**Jeanie Bourke - RE: 22 Hancock St., BP#2014-02364 (15 Middle)**

**From:** Jeanie Bourke [mailto:JMB@portlandmaine.gov]  
**Sent:** Friday, October 31, 2014 10:47 AM  
**To:** Matt Provencal  
**Subject:** 22 Hancock St., BP#2014-02364 (15 Middle)

1ST FLOOR PLAN
1/4"=1'-0"

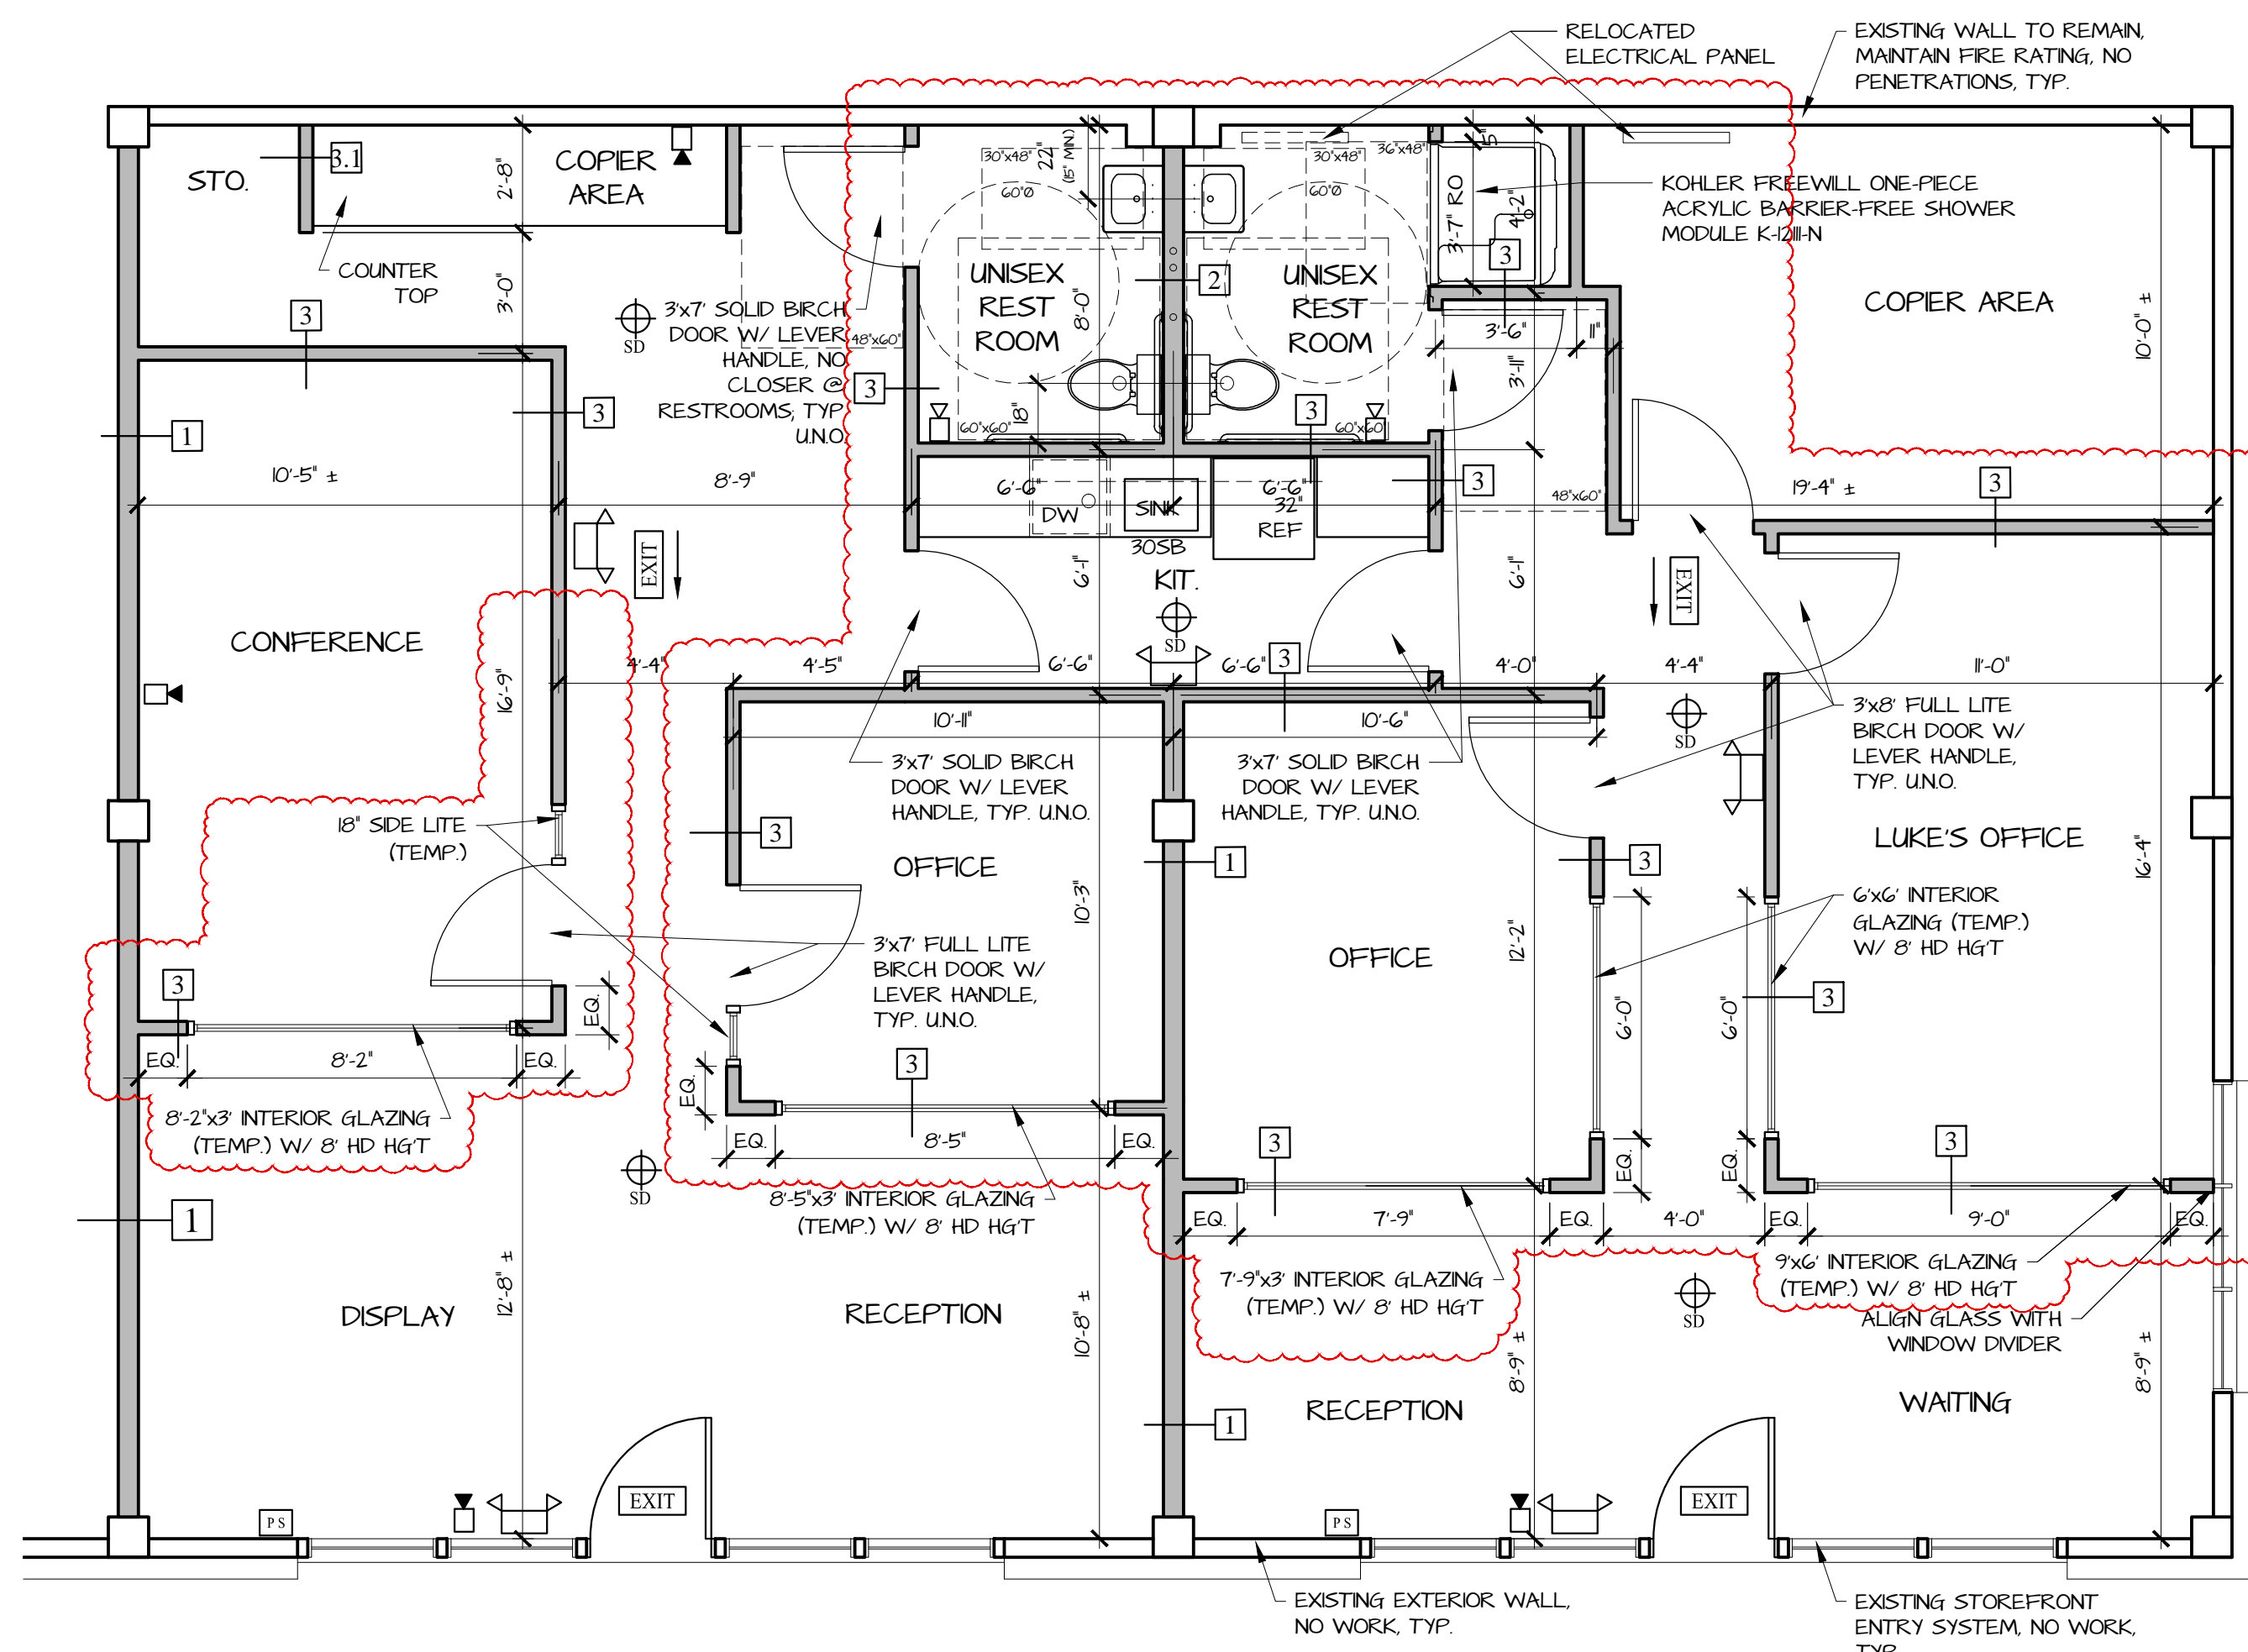
You applied for this under 15 Middle, however if you look closer, on the Assessors GIS map, you will see the work is being done in 22 Hancock.

When making application, this information should be utilized to confirm the property information. You can also submit the map, which will also provide the street boundaries. This is critical on buildings bordered by 2 or 3 streets, as you know the city address can be totally different from what is on the building. It is always helpful to include the streets on the key plan for building orientation.

1. The plan does not show any wall demo, was this a vanilla box, or are there existing tenant or condo demising walls? If so, the plan should reflect this, as 2 condos are merging. **There are currently no walls existing at any of the 3 spaces. The condos are staying as two separate entities purchased by one buyer; this would not be a merger. The spaces simply share a kitchenette.**
2. What is the ceiling design? Do you have a RCP, or is it all ACT? **We have not put together a RCP as it will all be suspended acoustical ceiling tiles...design build with lighting and HVAC.**
